WRITTEN REPRESENTATION FOR DEADLINE 1 – 20 MAY 2025

PLANNING INSPECTORATE REFERENCE NUMBER: EN020028

MADE ON BEHALF OF D LUND AND M FARE FARMING PARTNERSHIP

The relevant document of reference is MORGAN AND MORECAMBE OFFSHORE WIND FARMS: TRANSMISSION ASSETS Environmental Statement Volume 1, Annex 4.3: Selection and Refinement of the Onshore Infrastructure

**Drawing Number:**  
BP-GBR-MORG-REG-0175

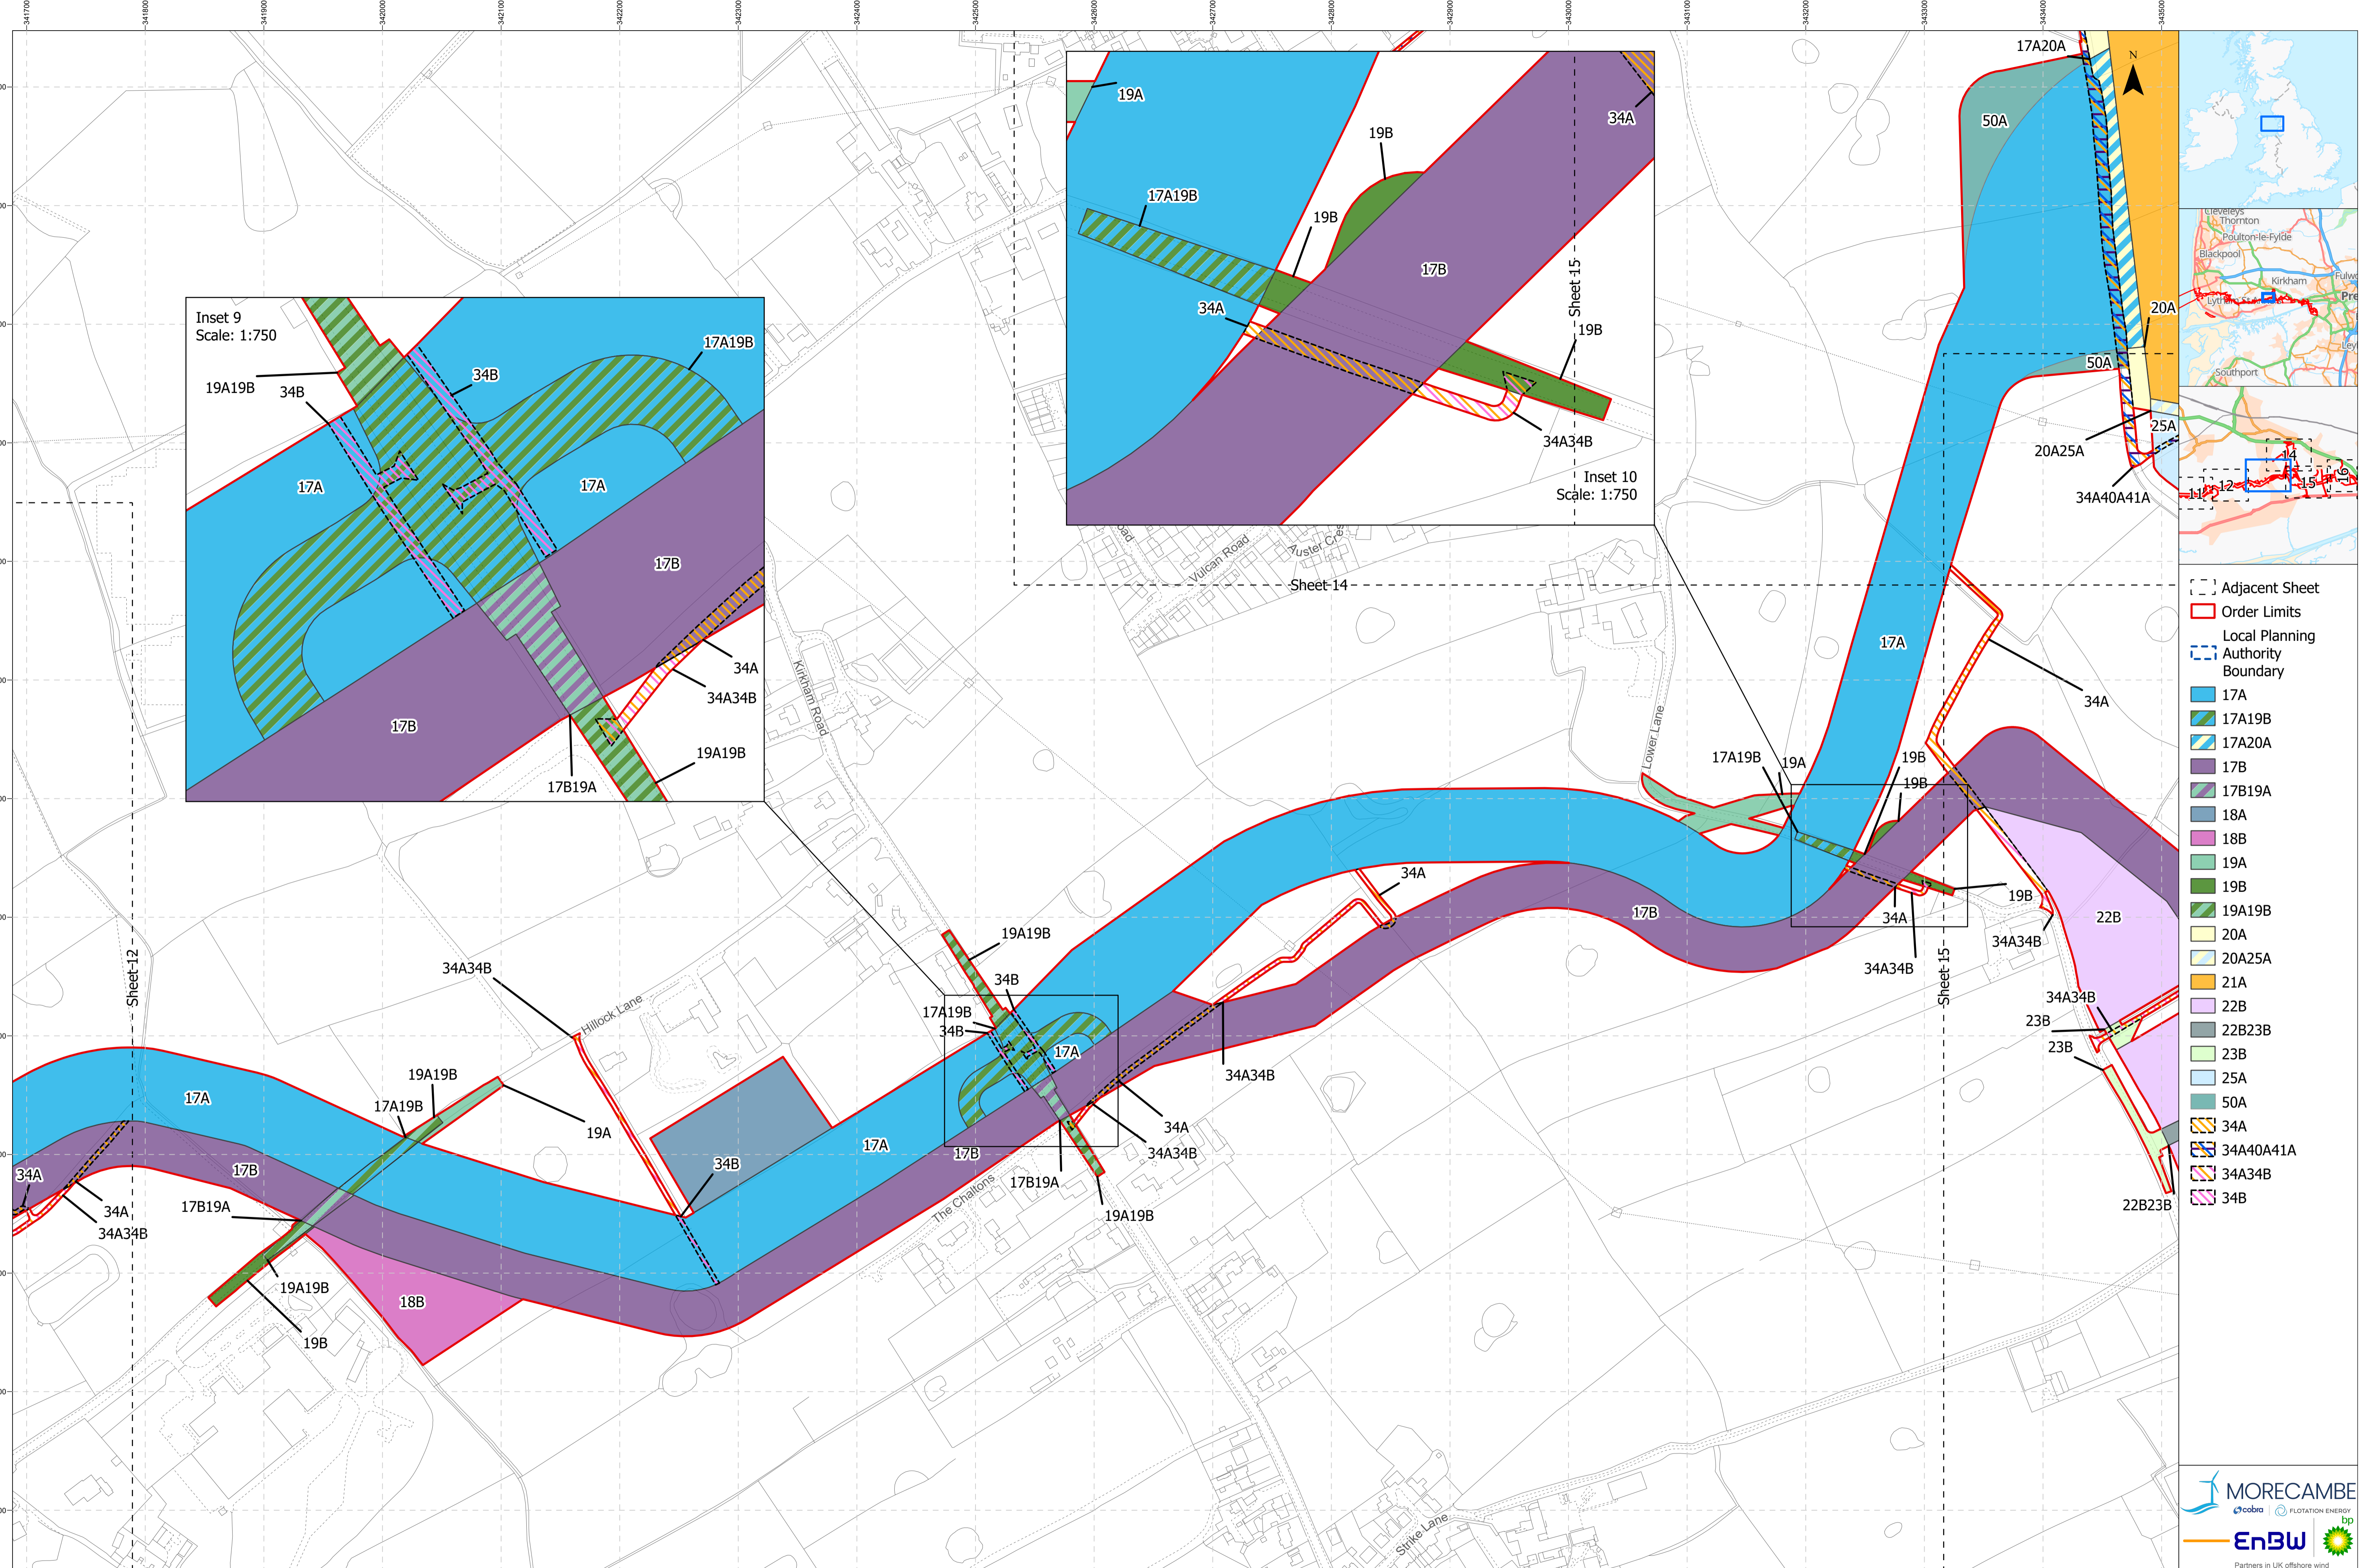
The Projects propose permanent access rights to access biodiversity mitigation areas over the private farm access road serving Greenbank Farm and Freshfield Farm identified as SI Works 34A40A41A. This proposed permanent access is wholly unnecessary as the Morgan Project will have permanent access from the A583. SI Works 34A40A41A impacts residential amenity and business security as the proposed vehicular access passes through residential properties off Lower Lane two residential farm properties and private farm yards.

There is a small triangular section of temporary works SI Works 22A which is proposed to be located on the west side of the proposed permanent haul road and whilst this is temporary area we consider this unnecessary for the construction of either the haul road or the substation. Project A has verbally agreed that this triangle area appears unnecessary however the Project would not remove this temporary area simply due to the fact that the planning application had been submitted. We request that this temporary area is removed from the planning application as unnecessary particularly given the large temporary compound to the east of the proposed permanent haul road. There is no need to disturb any additional land on the west side of the haul road as we consider this unnecessary for the construction of either the haul road or the substation. shown edged in blue on the attached identification plan.
